**WSCC CONSULTATION RESPONSE:  
County Planning – Minerals & Waste Planning Authority (MWPA)**

<b>TO:</b>	Arun District Council Case Officer: Jessica Riches		
<b>DATE:</b>	22 October 2024		
<b>LOCATION:</b>	Ford Airfield, Ford		
<b>SUBJECT:</b>	F/15/24/RES: Approval of reserved matters (layout, scale, appearance and landscaping) following outline permission F/4/20/OUT for phase reserved matters 1 (North), for the erection of 340 No. residential dwellings plus associated roads, infrastructure, parking, landscaping, open space & play areas and associated works.		
<b>RECOMMENDATION:</b>	<input type="checkbox"/> Advice	<input checked="" type="checkbox"/> Objection	
	<input type="checkbox"/> Modification	<input type="checkbox"/> No Objection	
	<input checked="" type="checkbox"/> More Information	<input type="checkbox"/> Refusal

Figure 4-1: Commercial & Industrial Operations

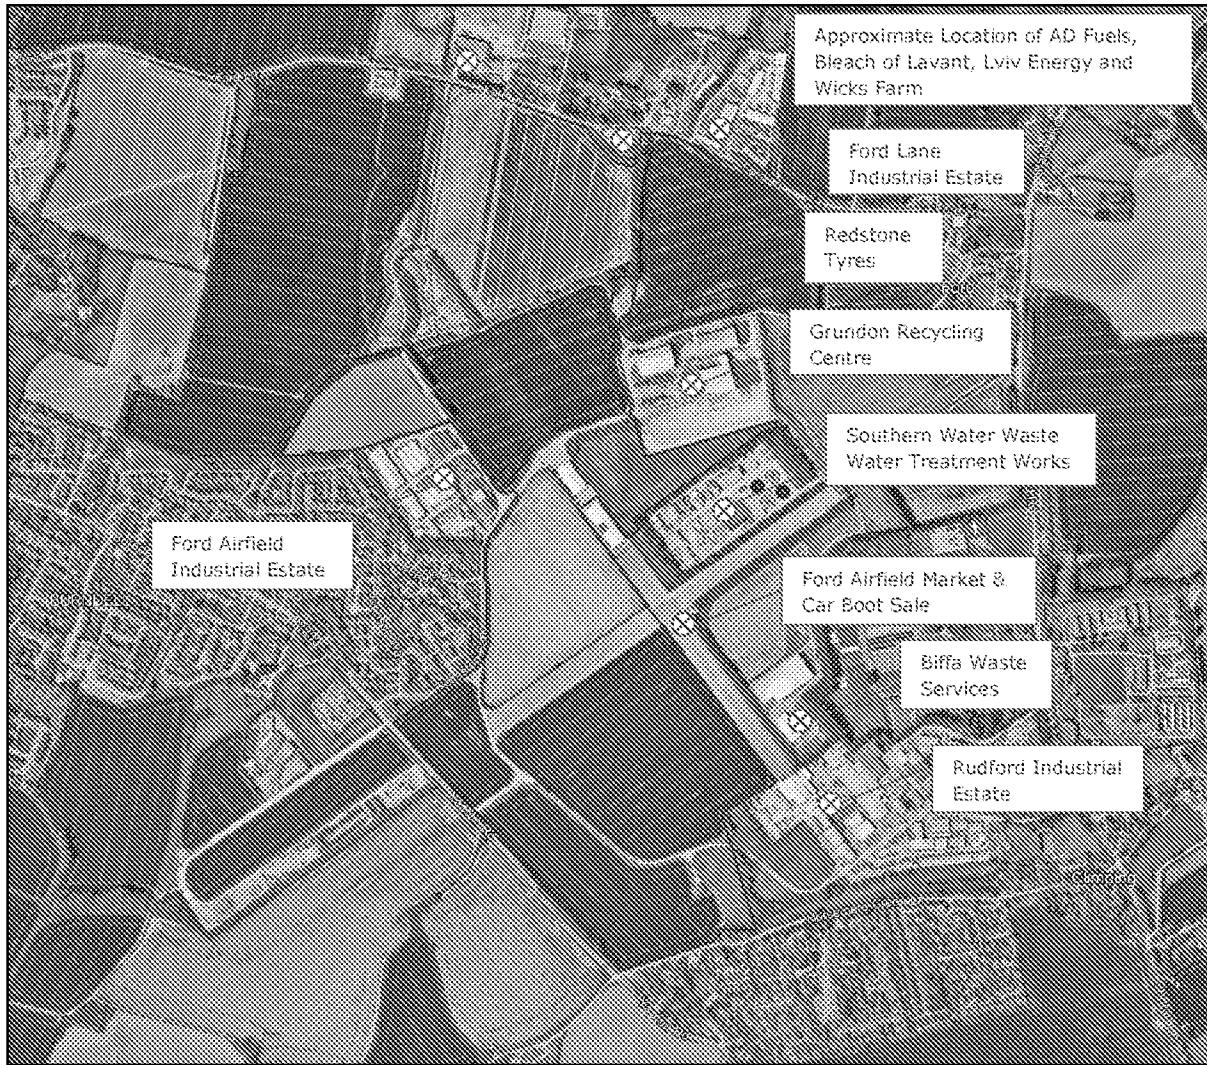
It is unclear the extent to which the noise assessment has considered a likely worst-case scenario for noise generated by the Metal Recycling Facility, and the part implemented Grundon Waste Facility within the Circular Technology Park site (or whether this is based on monitored levels over a limited survey period?). It is crucial that any assessment of noise arising from these facilities is representative of the full extent of their permitted activities and potential future waste uses for which the Circular Technology Park Site is allocated.

As raised in our previous responses to F/4/OUT, there remains a failure to demonstrate that conditions attached to existing waste sites (which set specified noise limits at the nearest residential receptors) would remain operable. For the existing Metal Recycling Site, Condition 7 of WSCC/012/12/F requires that the noise rating level from the waste facility at the nearest sensitive residential premises does not exceed 5dB above background. No evidence is provided that demonstrates this pre-existing condition (and thus the existing waste use) would remain operable.

Similarly, in terms of the noise relationship with the extant, part implemented, Grundon Waste Facility, the WIS concluded that several residential premises would experience noise levels in the order of 35-39dBA. Condition 28 of WSCC/096/13/F requires that the noise rating level from the waste facility at the boundary of the nearest sensitive residential premises (not habitable rooms) does not exceed 35dBA at any time. The submitted noise assessment at Table 4-1 and paragraph 4.25 suggest a rating level of 36dB at the nearest residential properties, which would render this pre-existing condition (and thus the existing

Therefore, WSCC request **further information** be provided to address the matters raised above. Until such time as further information has been provided, we have a **holding objection** to the approval of this reserved matter and the (part) discharge of condition 25.
